July 3, 2018

**Re: Shops @ The 24's**  
**2424 Louisiana Blvd NE, 87110**  
**Traffic Circulation Layout**  
Engineer's/Architect's Stamp 06-26-18 (H19-D001)

Based upon the information provided in your submittal received 06-27-18, the above referenced plan cannot be approved for Building Permit until the following comments are addressed:

OVERALL SITE PLAN
NOT TO SCALE

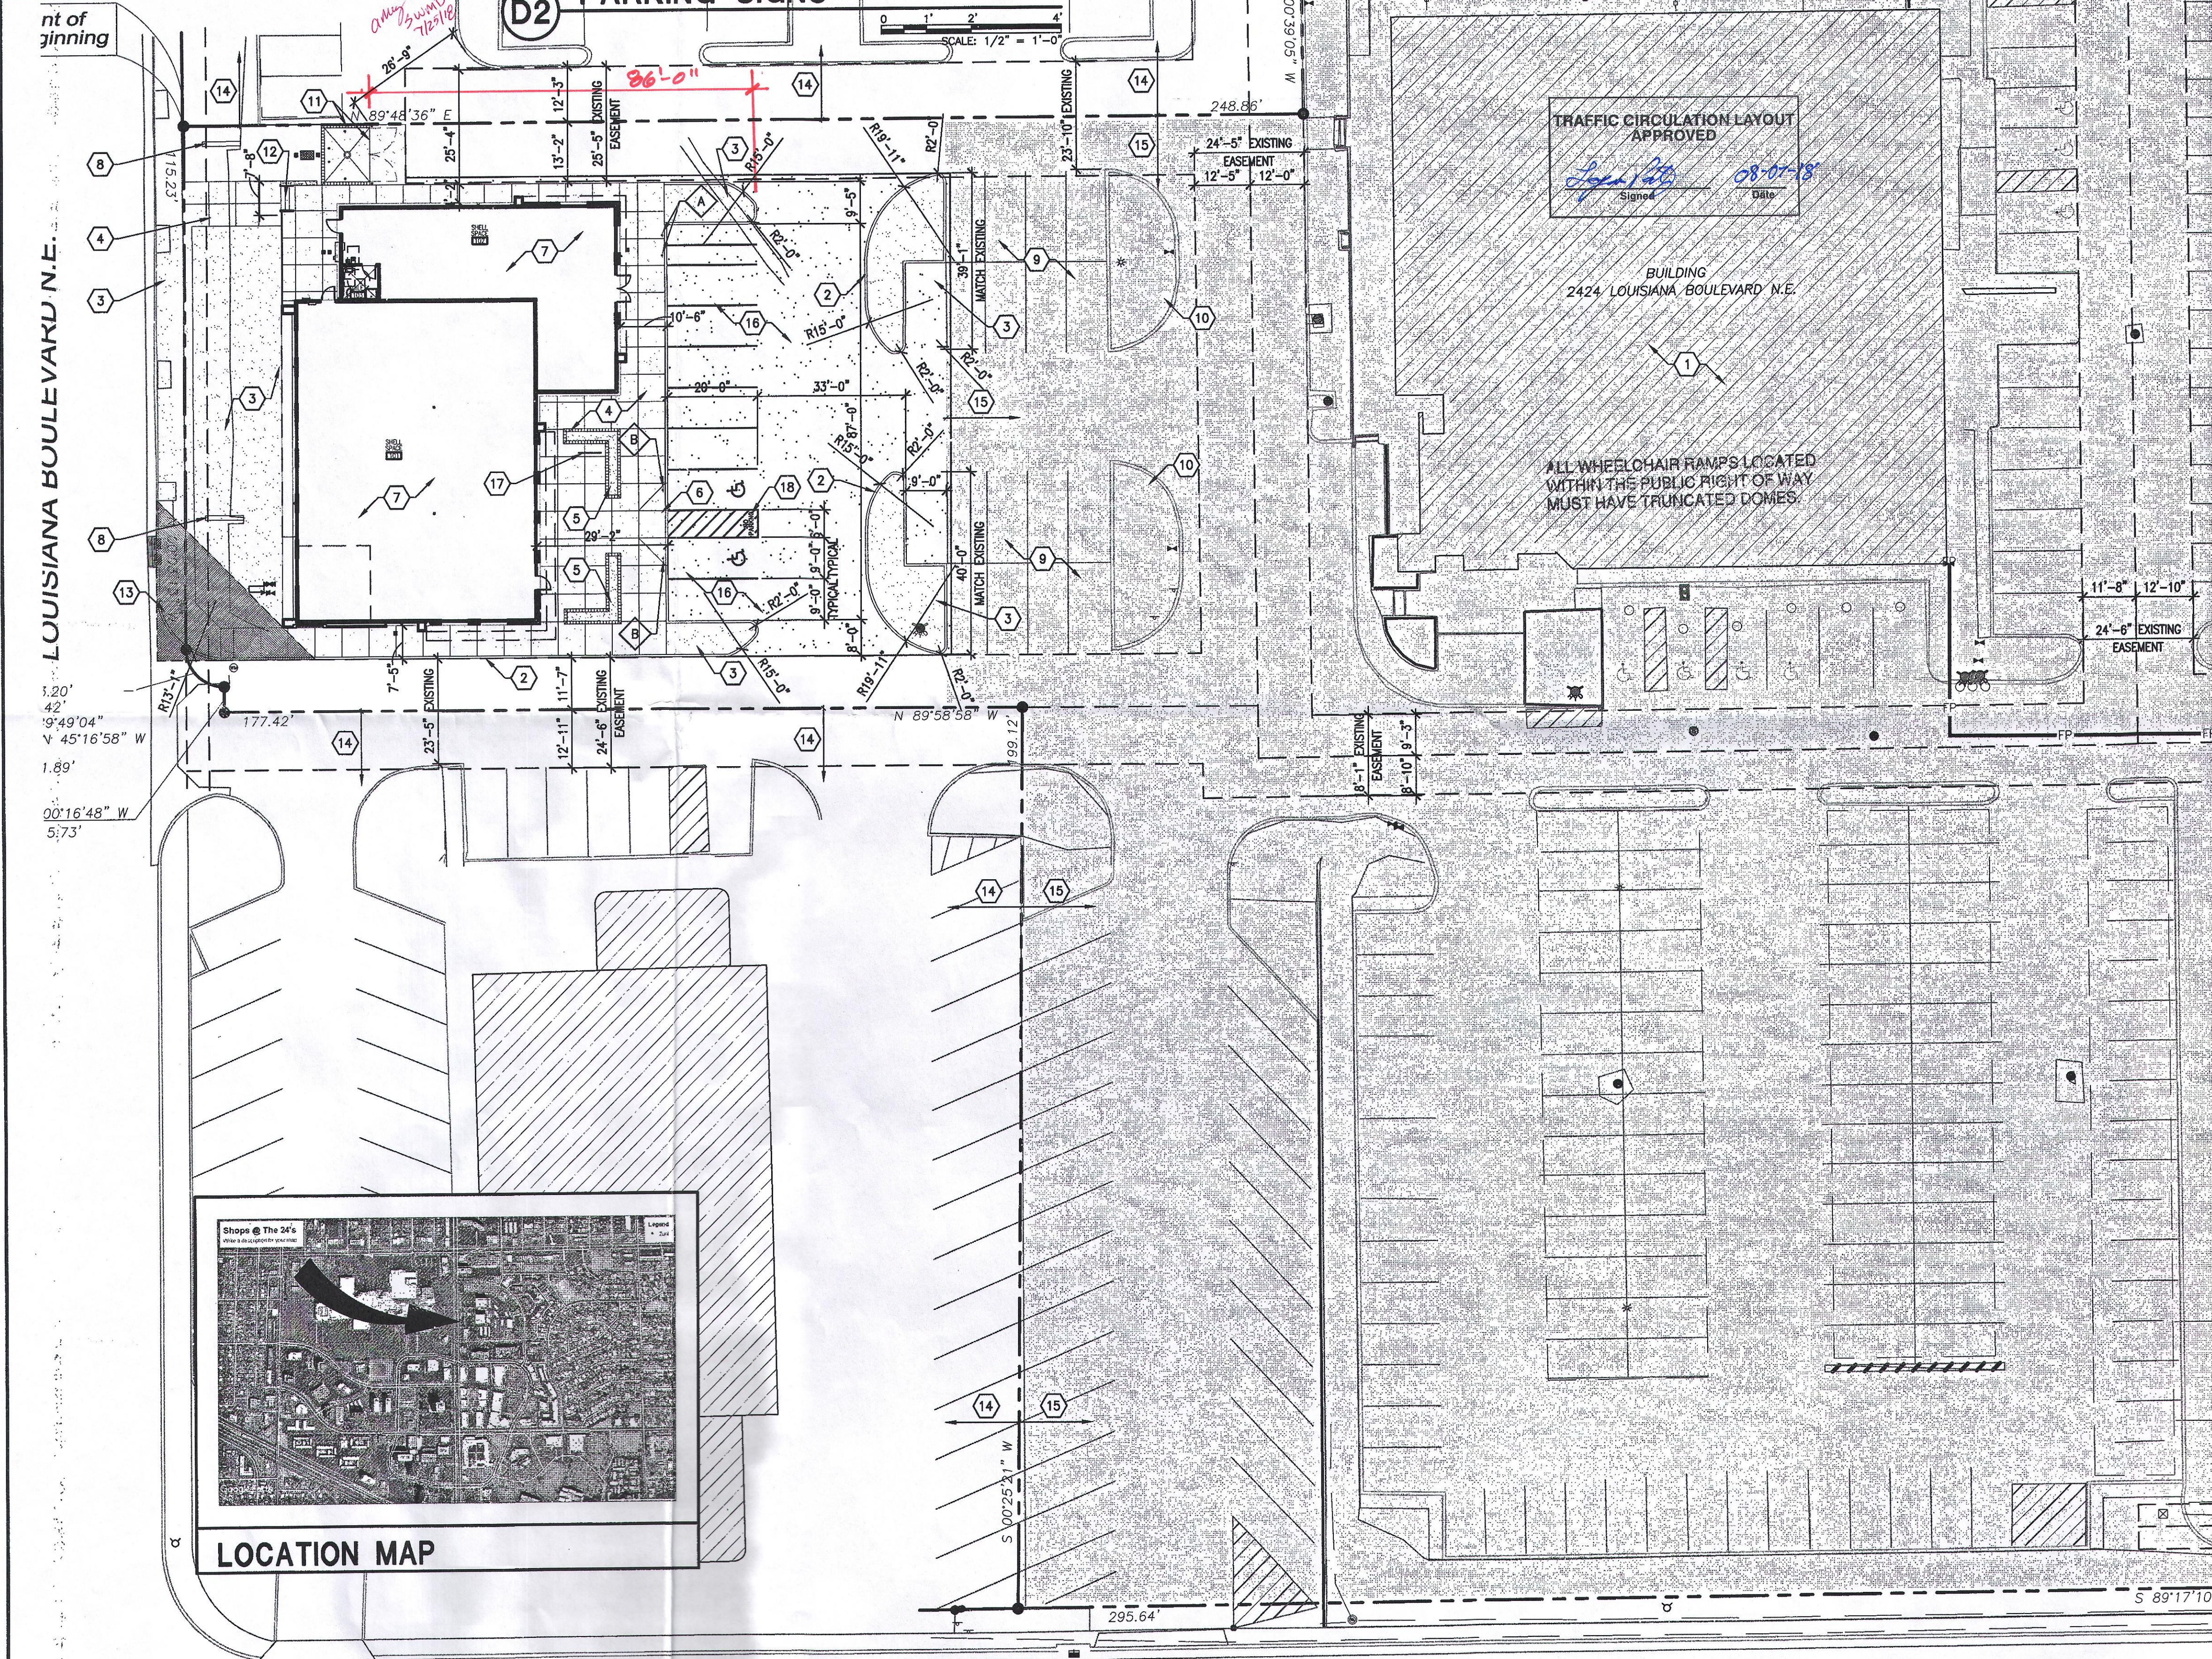
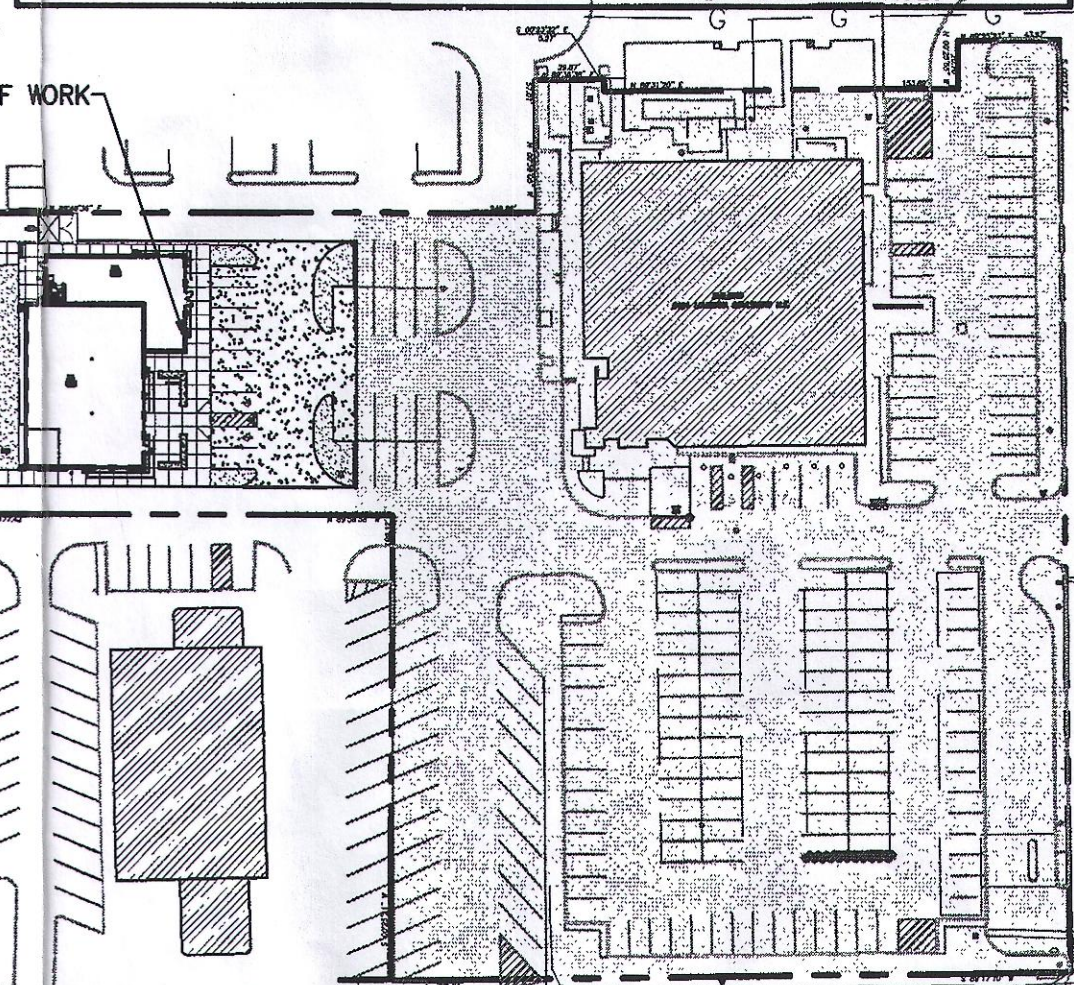
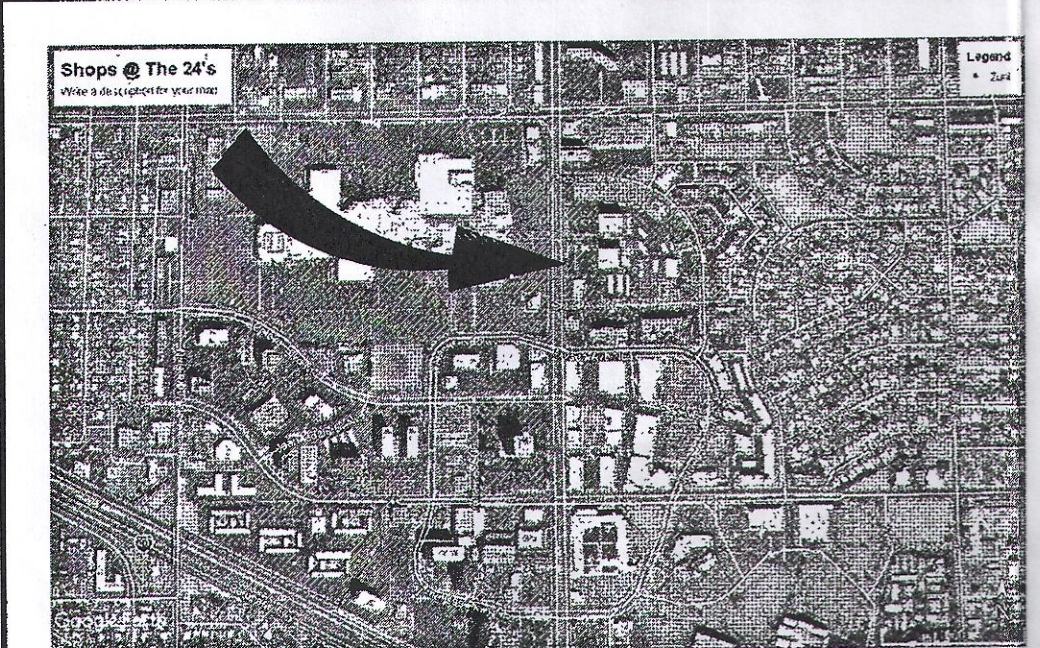
1. Identify all existing access easements and rights of way width dimensions.
2. The ADA accessible parking sign must have the required language per 66-7-352.4C NMSA 1978 **"Violators Are Subject to a Fine and/or Towing."** Please call out detail and location of HC signs.

3. The ADA access aisles shall have the words **"NO PARKING"** in capital letters, each of which shall be at least one foot high and at least two inches wide, placed at the rear of the parking space so as to be close to where an adjacent vehicle's rear tire would be placed. (66-1-4.1.B NMSA 1978)

4. Please provide distance from ADA ramp to entrance of building.
5. Motorcycle parking spaces shall be designated by its own conspicuously posted upright sign, either free-standing or wall mounted per the zoning code.

6. Please add bicycle parking per zoning requirements.
7. Service vehicle and/or refuse vehicle maneuvering must be contained on-site; provide a copy of refuse approval.

8. It is not apparent what type of pavement surface is being proposed. A hard driving surface will be required as part of this proposed project for parking area and drive aisles.

9. Add the following note to the plan: "Landscaping and signage will not interfere with clear sight requirements. Therefore, signs, walls, trees, and shrubbery between 3 and 8 feet tall (as measured from the gutter pan) will not be acceptable in the clear sight triangle."

10. Please include a copy of your shared access agreement with the adjacent property owner.

11. All landscaping to be kept within property boundary.
12. Provide notes showing what work is included and on the work order and the private work on site.
13. Work within the public right of way requires a work order with DRC approved plans.
14. Please add a note on the plan stating "All improvements located in the Right of Way must be included on the work order."
15. Please include two copies of the traffic circulation layout at the next submittal.
16. List radii for all curves shown; for passenger vehicles, the minimum end island radius for passenger vehicles is 15 ft. Radius for delivery trucks, fire trucks, etc. is 25 ft. or larger.
17. Please provide previously approved DRB site plan showing the lots to the north.
